Our Case Number: ABP-318607-23

Re: Proposed construction of a residential led mixed use scheme across 16 blocks within 9 buildings ranging in height from 4 to 15 storeys
Lands at Park West Avenue, Cherry Orchard Dublin 10. Bound by Cloverhill Road to the north, Cedar Brook Avenue and Park West Avenue to the east, Park West Cherry Orchard Rail Station to the southeast & the M50 to the west

Councillor Sophie Nicoullaud & TD Joan Collins observation

ABP Case number :318607

Figure 2.4 - Heights Diagram

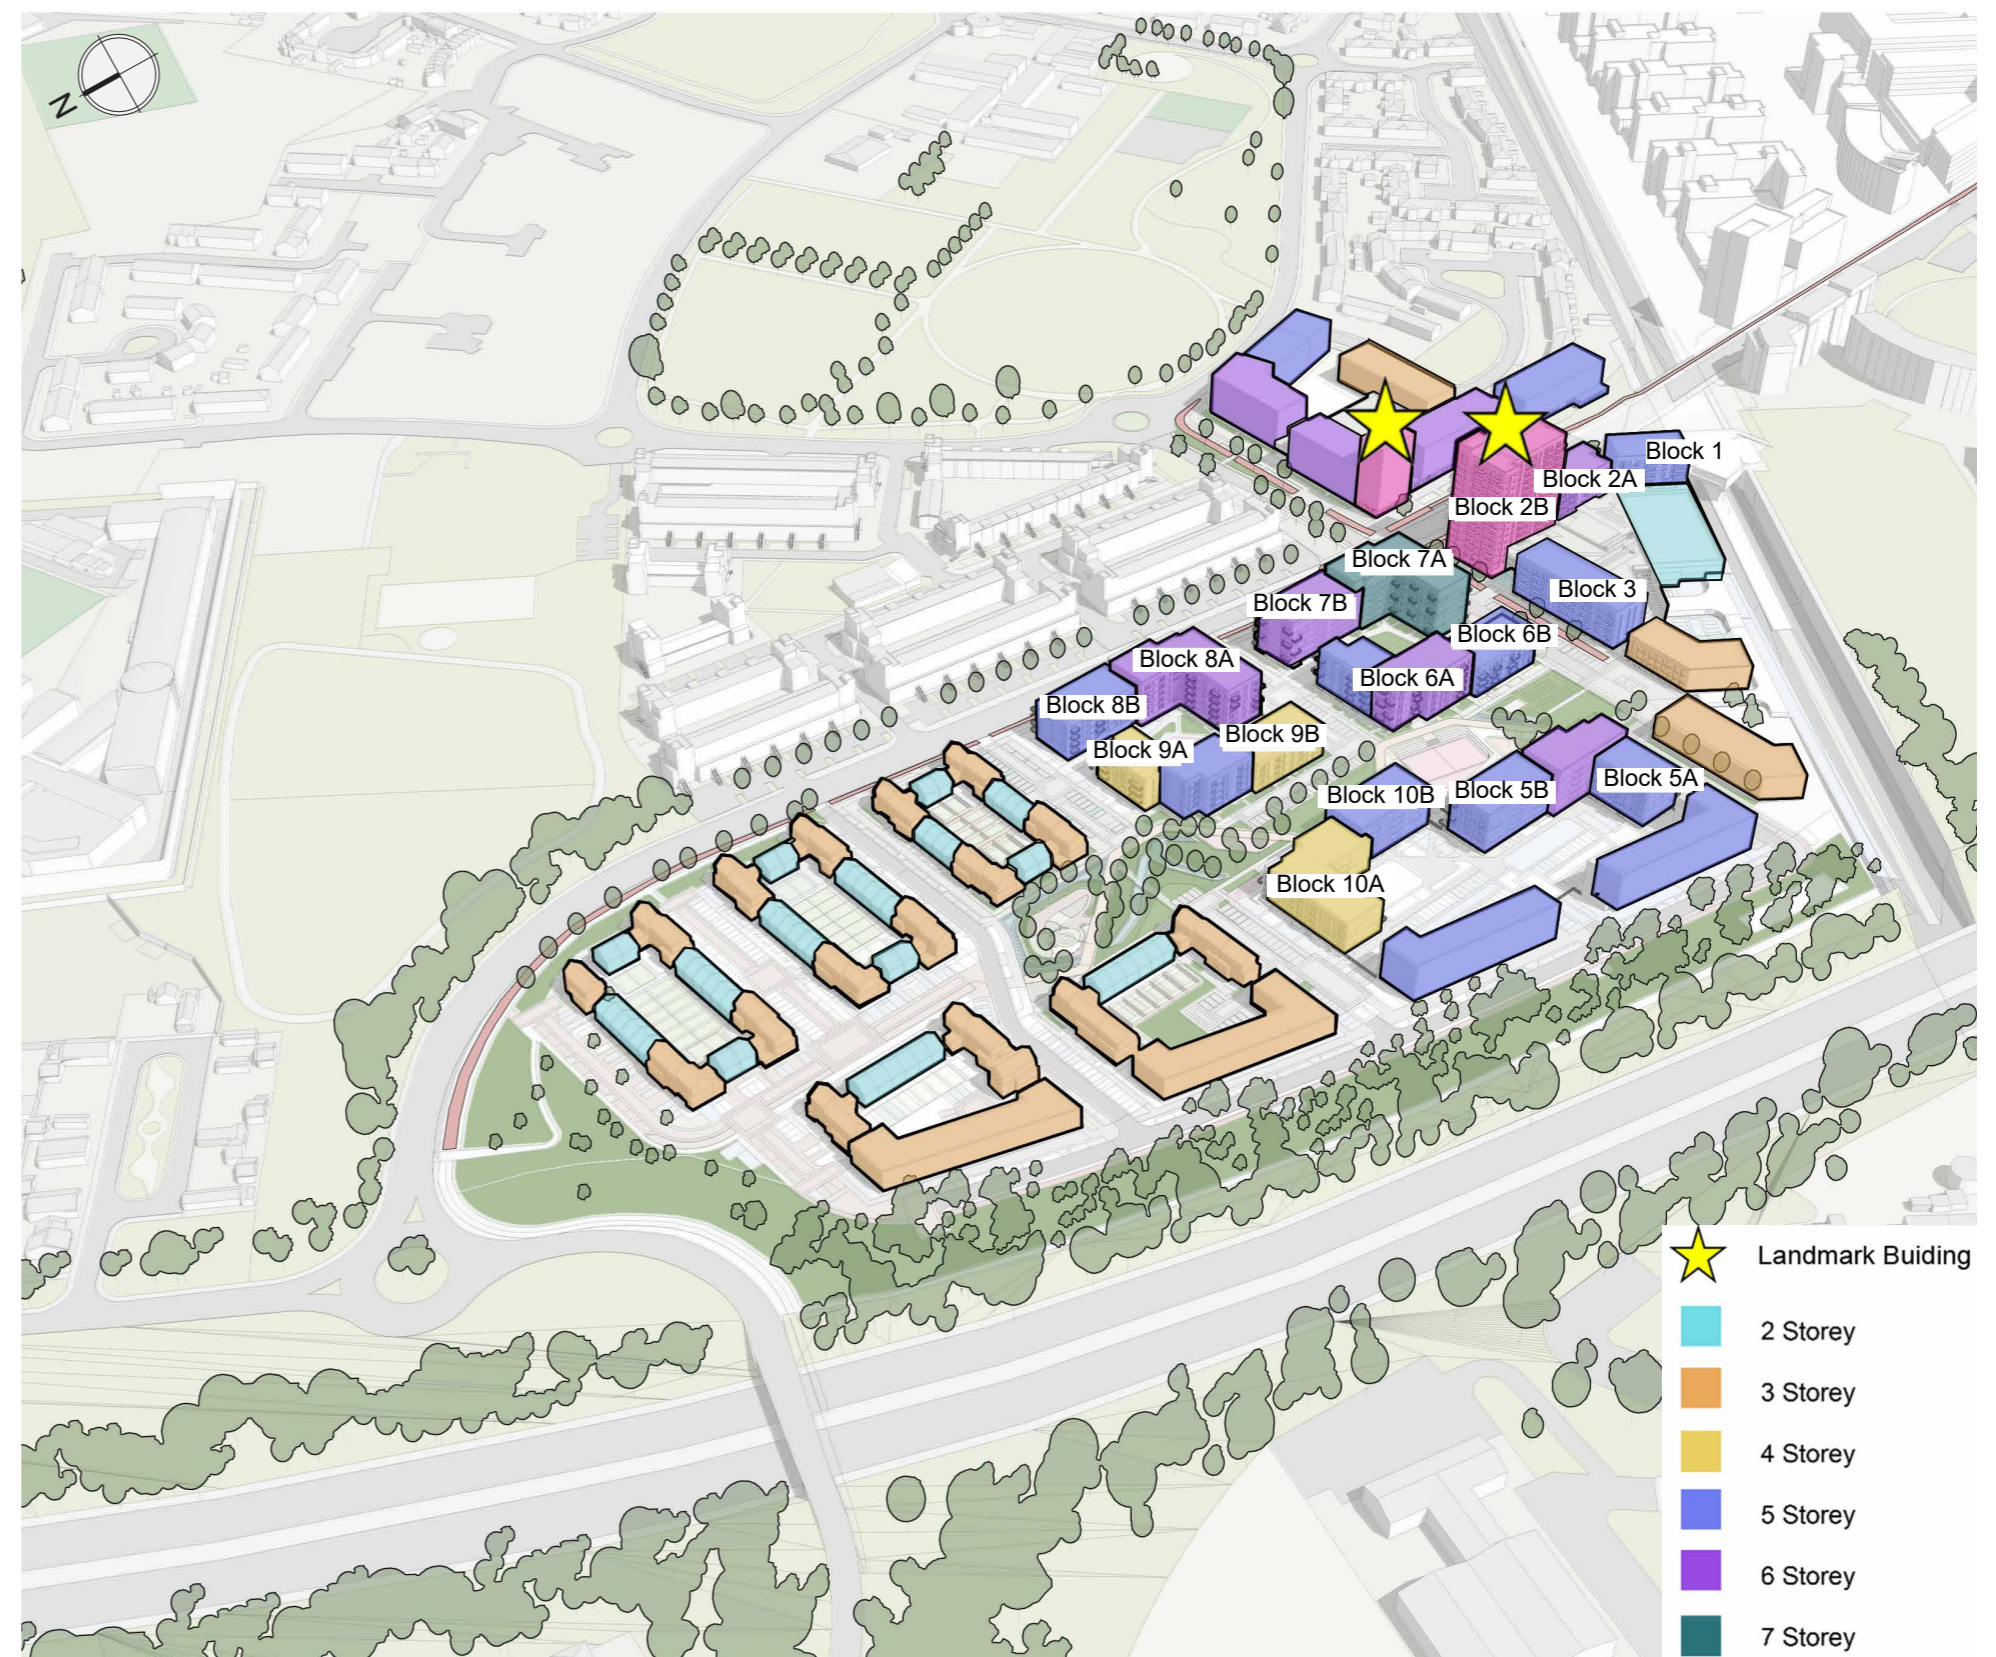
Figure 2 below has an inaccurate legend with pink colour missing any explanation and square representing building with no height details. The 2 landmark buildings have a yellow star are both pink in colour but one is to be a 15-storey building in phase 1 and the other it is unclear from all the various images and LAP and this proposal of what height it is proposed to be.
